SYDNEY METRO VICTORIA CROSS OSD CONCEPT SSD DA MODIFICATION (SSD- 8874-MOD-1) & DETAILED SSD DA (SSD-10294)

RESPONSE TO SUBMISSIONS

The Department of Planning, Industry and Environment (**DPIE**) issued a letter to the applicant on the 5 December 2019, requesting a response to the comments raised during the public exhibition period for both the Concept SSD DA Modification application (**SSD-8874-Mod-1**) and the Detailed SSD DA (**SSD-10294**).

COMPARISON OF APPROVED AND MODIFIED ENVELOPES

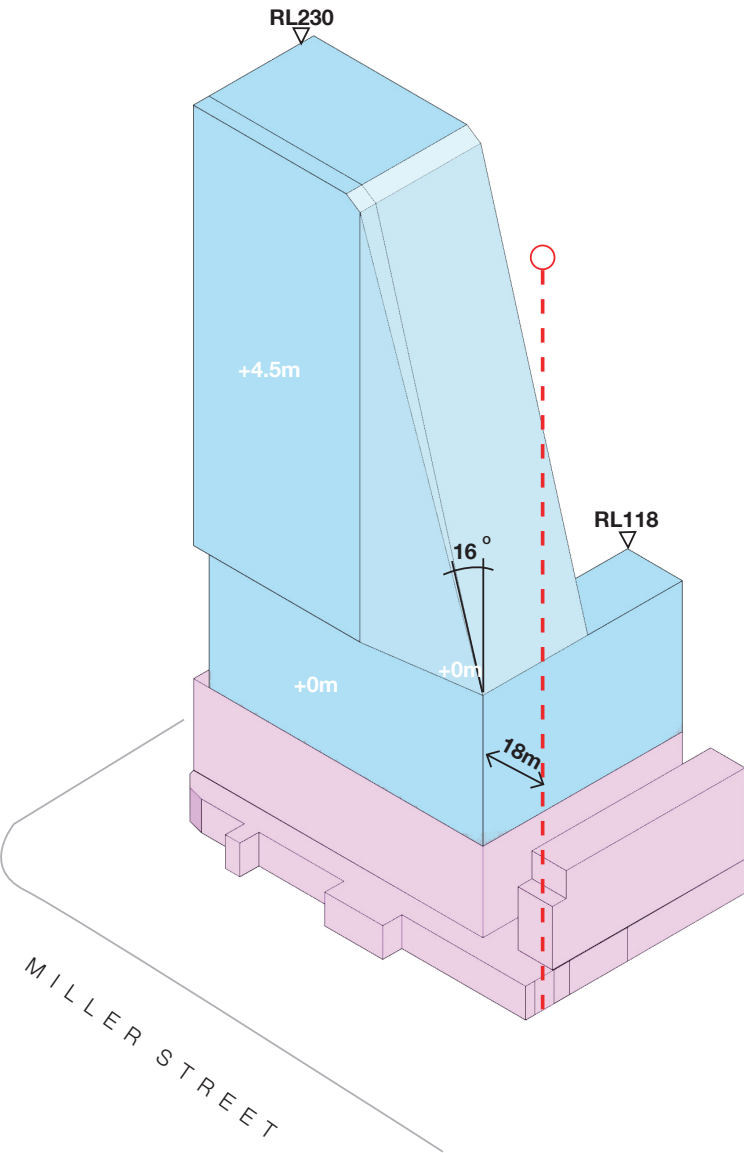
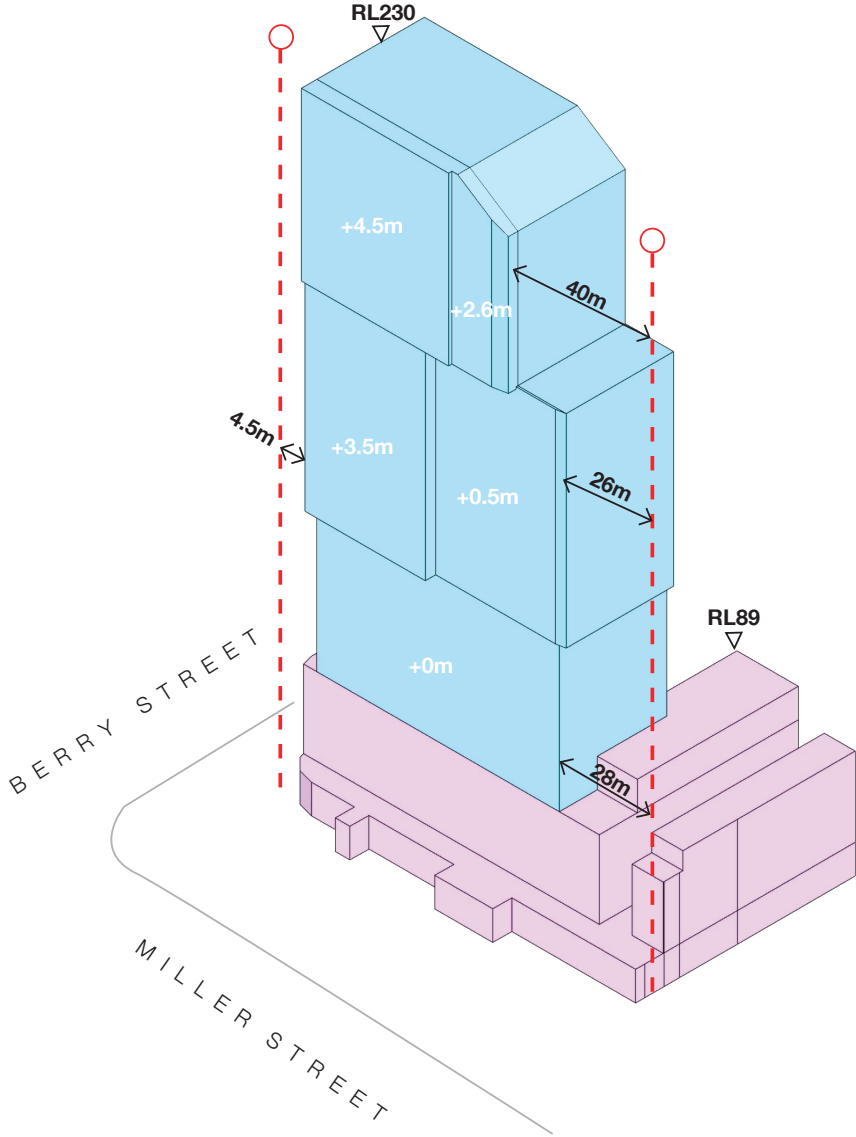
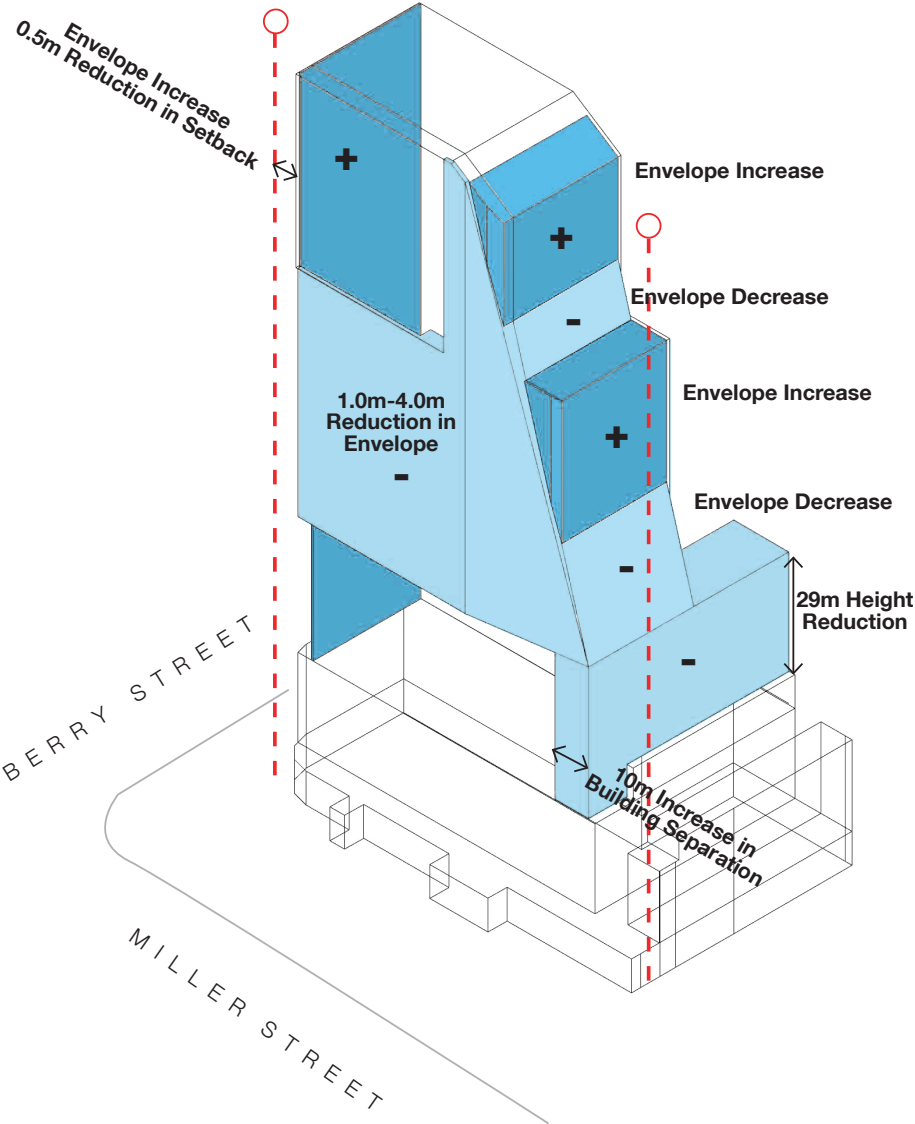
Issue / Matter	Comment	Response
<p>2. Built form and setbacks</p>	<p>Provide further justification for the proposed built form with respect to:</p> <ul style="list-style-type: none"> a) the design of the tower within the articulation zone and how the specific design criteria in the approved Design Guidelines have been addressed b) the proposed modifications to the building envelope and distribution of massing in relation to the view loss and amenity concerns raised in public submissions c) Condition A15 which requires the building not to exceed the approved building envelope. <p>Note: The Department is requesting schedules of actions from the Sydney Metro Design Review Plan (DRP) to further consider how the advice of the DRP have been addressed by the project. The Department in reviewing the schedules, may seek further clarifications on the project responses to DRP advice.</p>	<p>Articulation zone and Design Guidelines:</p> <p>The articulation zone of the approved building envelope has a volume of 28,950 cubic metres, whereas the modification to the building envelope has a volume of 19,385 cubic metres in the articulation zone. This equates to a reduction of 9,565 cubic metres from the approved to the modified envelope.</p> <p>The detailed design of the OSD consists of 14,875 cubic metres of built form within the articulation zone of the modified envelope. This equates to a reduction of 4,510 cubic metres. The detailed design of the OSD occupies approximately 77% of the modified envelope articulation zone, and 50% of the approved envelope articulation zone.</p> <p>The proposal therefore addresses Clause 5.3(3) of the approved Victoria Cross OSD Design Guidelines which states ‘<i>the building form within the “articulation zone” of the Miller Street frontage of the building envelope may utilise some (not all) of the nominated zone.</i>’</p> <p>As stated in the supplementary Design Report prepared by Bates Smart (Appendix A), the proposed massing within the articulation zone has been designed to meet other relevant Victoria Cross OSD Design Guidelines as follows:</p> <ul style="list-style-type: none"> The proposed massing complies with overshadowing requirements of the NSLEP 2013. The proposed massing incorporates horizontal recessed articulation and varied façade depths at the lower levels of the OSD tower which align with the height and scale of the adjacent MLC Building (refer to the Heritage Impact Assessment and Heritage Interpretation Report submitted with SSD-10294 for further discussion on the proposed built form compatibility). The proposed massing provides varying articulation depths throughout the low, mid and high rise levels to maintain sky views (e.g. there is no built form cantilever to Miller Street below level 15). The detailed design has

Issue / Matter	Comment	Response
		<p>removed 14 storeys of commercial office space previously situated on the northern side of the laneway. This together with an increased separation from the OSD tower component to the MLC Building significantly improves sky views when compared to the approved envelope.</p> <ul style="list-style-type: none"> • The proposed massing design in the articulation zone breaks up wind paths and reduces downdrafts at the western interface of the tower (Miller Street). As demonstrated in the Wind Impact Assessment submitted with SSD-10294, wind conditions at the base of the tower in the Miller Street public domain (i.e. beneath the articulation zone) are amongst the lowest and most comfortable across the site. Wind impacts are further mitigated by increasing the setback from the southern property boundary to the OSD tower and removing the need for a glass awning above the laneway (approved envelope). <p>Distribution of massing, mitigating view loss and amenity concerns:</p> <p>The approved building envelope has a zero-metre setback to the eastern boundary and a 5m setback to the northern boundary (Berry Street).</p> <p>While the proposed modification to the building envelope reduces the approved setback from the northern boundary (Berry Street) from 5m to 4.5m, plus shading structures, the proposed detailed design provides an additional 3m setback to the eastern boundary in the north eastern corner of the site. The inclusion of this setback to the eastern boundary creates an additional view corridor from the Alexander Apartments to the north west, when compared to the approved building envelope.</p> <p>As illustrated in the supplementary Design Report (Appendix A), the reduction of the northern setback by 0.5m and the inclusion of additional shading elements outside of the building envelope maintains an additional view corridor to the Alexandria Apartments compared to the approved building envelope. Further, the additional 3m setback to the eastern boundary improves solar access and general outlook from the Alexandria Apartments</p>

Issue / Matter	Comment	Response
		<p>compared to the approved building envelope, notwithstanding the proposed changes to the approved building envelope, as evidenced in the view impact studies and shadow analysis included within this response.</p> <p>Exceeding the approved envelope (Condition A15):</p> <p>The detailed design of the proposed tower has progressed concurrently with the proposed modified building envelope, and the tower has been designed to comply with the building envelope as sought to be modified with the only exception being the sun shading devices.</p> <p>Notably, the external sun-shades (vertical fins) project 490mm beyond the modified envelope on the north façade and 100mm beyond the modified envelope on the low rise levels of the south façade facing the laneway.</p> <p>This is considered acceptable, despite the projection of the north façade, as the built form of the OSD enables improved views and solar access to the north-west oriented apartments within the Alexander Apartments. This is achieved by increasing the setback distance (3 metres) from the OSD tower to the north-east corner of the site (adjacent to the Denison and Berry Street intersection).</p> <p>Similarly, despite the low-rise levels of the south façade extending beyond the modified envelope, solar access and view outlook throughout the precinct is significantly improved by increasing the separation distance from the OSD tower to the adjacent MLC Building from 18 metres to 28 metres (10 metre increase) compared to the original approved envelope.</p> <p>The vertical fins are a key architectural expression of the detailed design which further articulate the built form. In addition, the vertical fins mitigate glare impacts from the glass façade and reduce direct heat impacts to internal commercial floor plates, thus improving sustainability outcomes for the operation of the OSD.</p>
